Application No: BE/59/21/PL
Site Address: 339 Chichester Road Bersted PO21 5AN
Description of works: Replacement of blockwork boundary wall with fence and new vehicular access (resubmission of BE/149/21/PL).

Thank you for your internet representation made on 14th May 2021 which has been recorded as an objection with the comments as follows:

SITE PLAN - SHOWING VISIBILITY SPLAYS
1:500 SCALE (at A3)

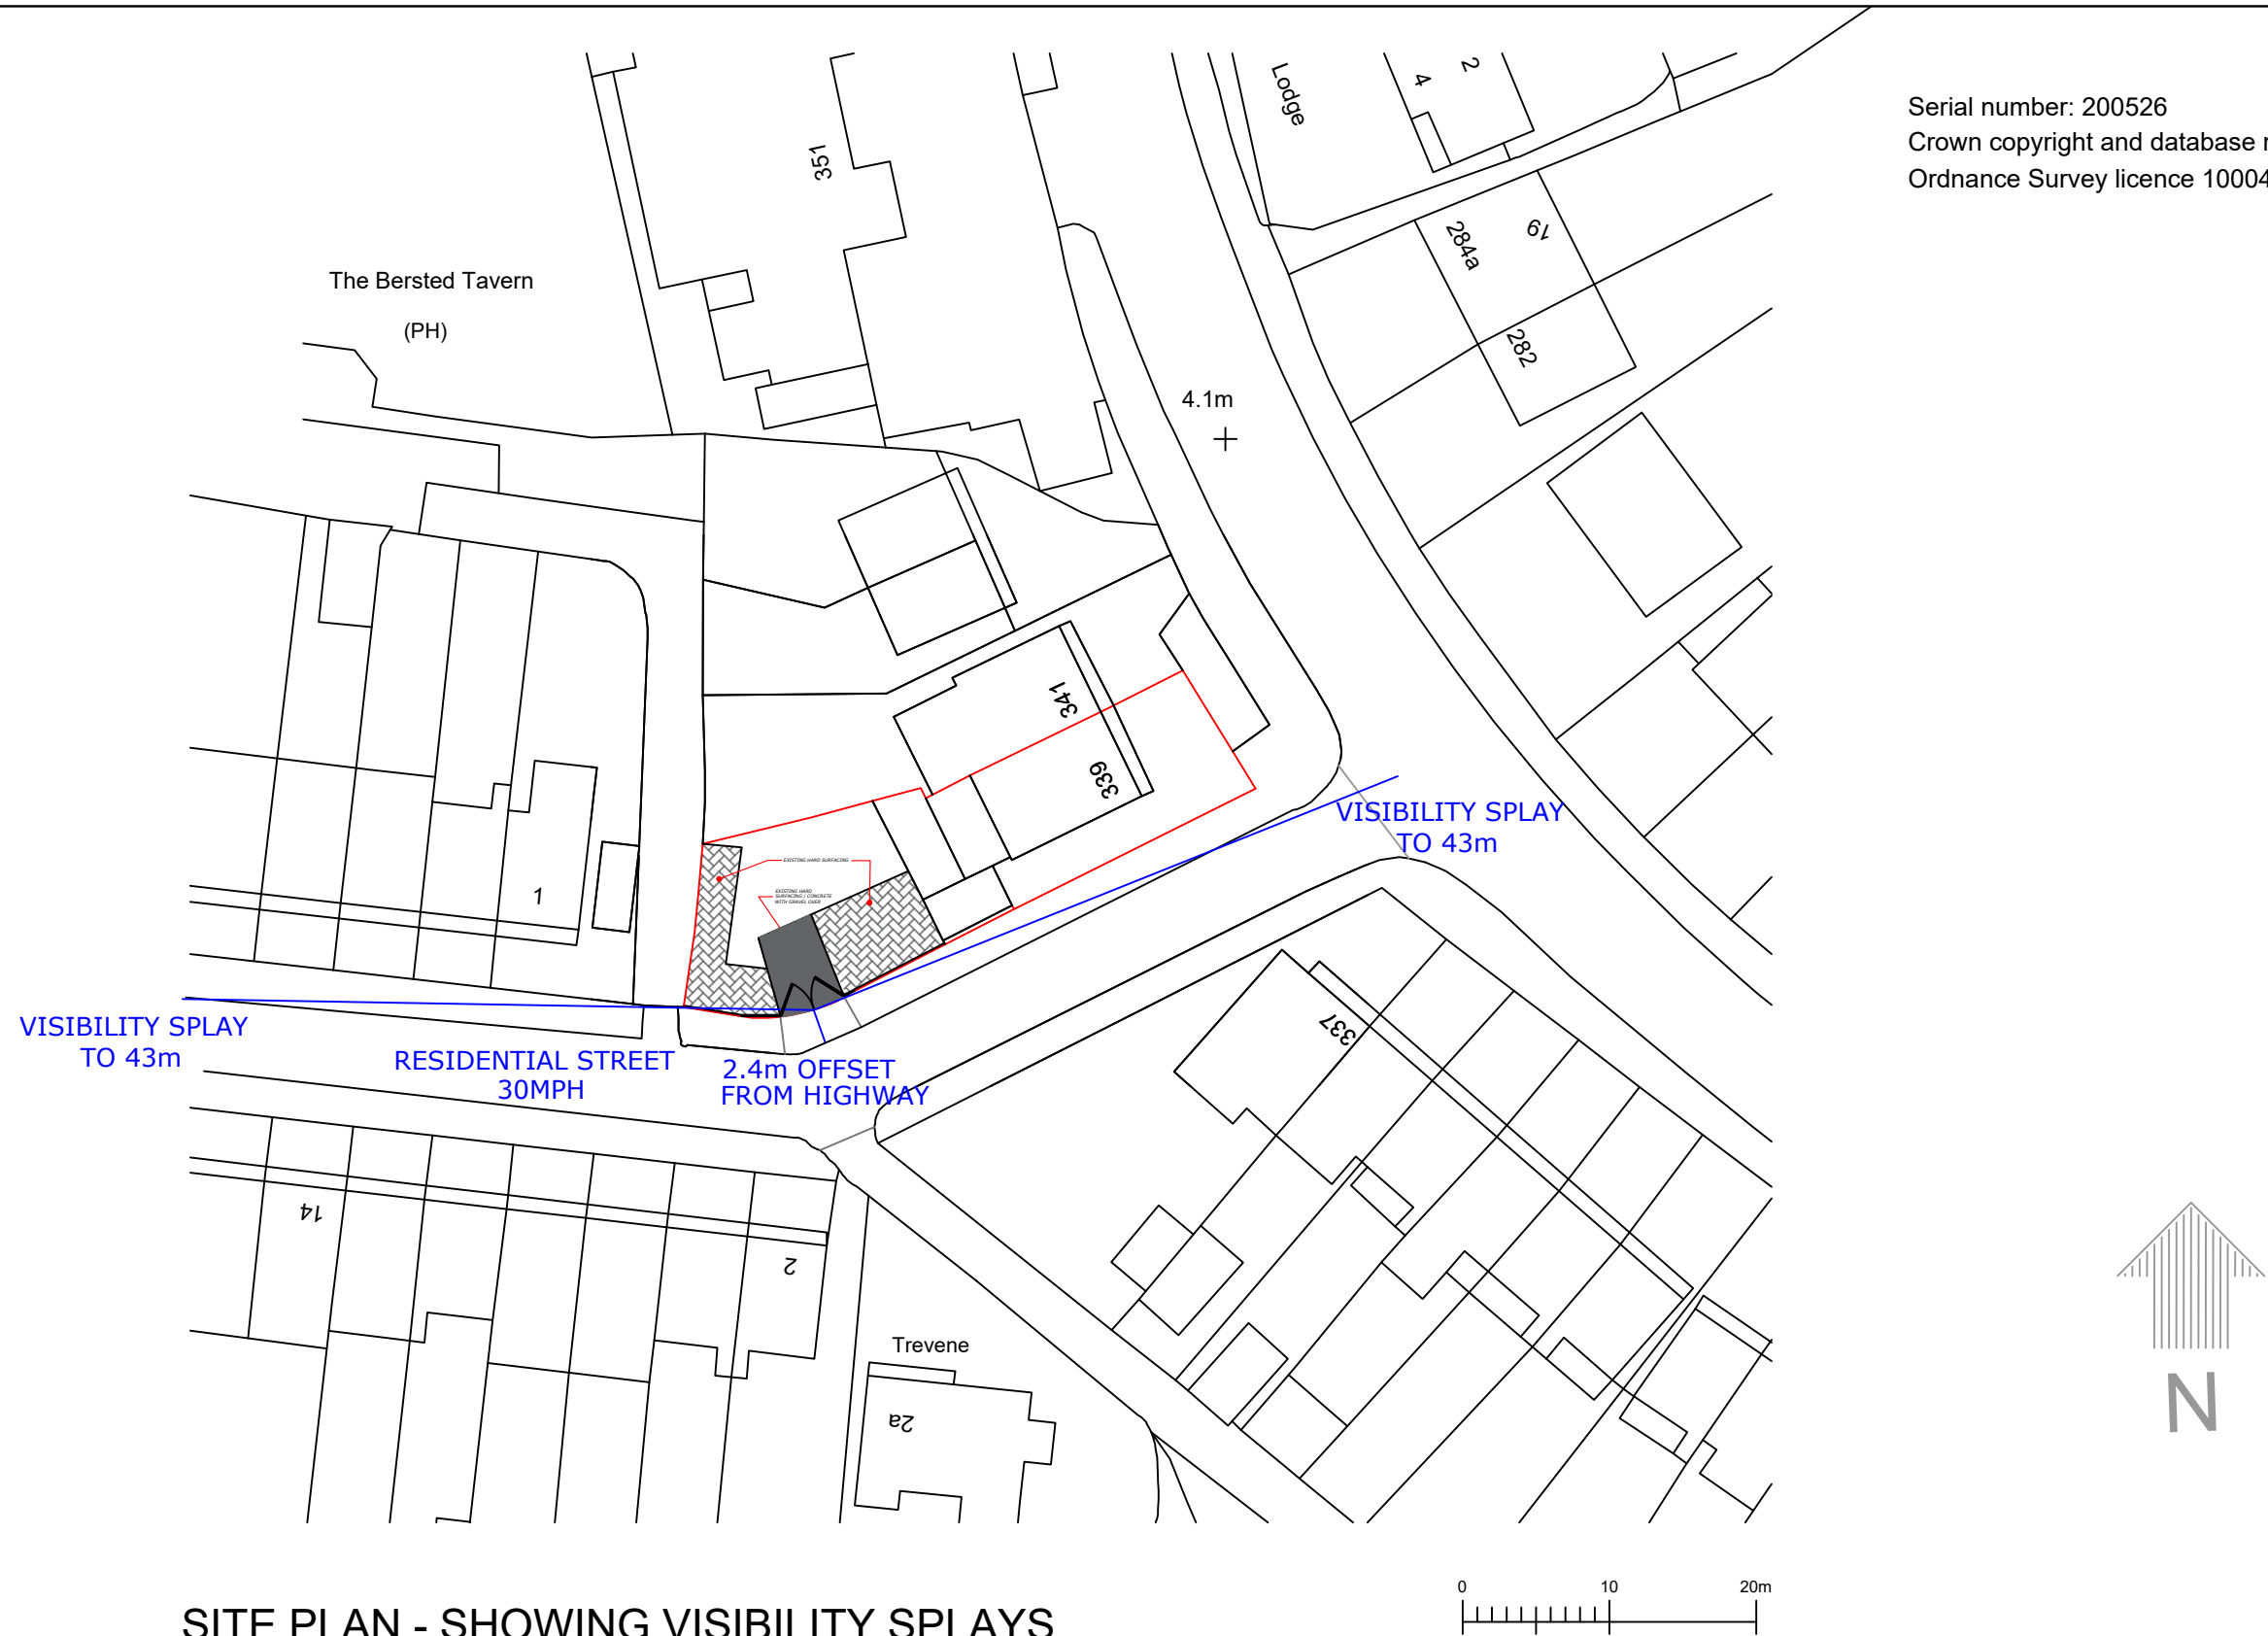
The proposed access does not appear to meet the necessary boundary requirements, with a maximum height of 600mm or with a fence set back from the boundary. This is a hazard to pedestrians as a vehicle pulling out of this access will not have the visibility of these pedestrians.

Also, the proposed access is in the middle of a road safety feature (bollards each side, albeit some have gone missing), this was intended to stop vehicles parking on the road. With some of the bollards now missing, vehicles are constantly parked either side of the proposed entrance, reducing the visibility splay well below the 43m required. Again this is dangerous for road users, including cyclists.
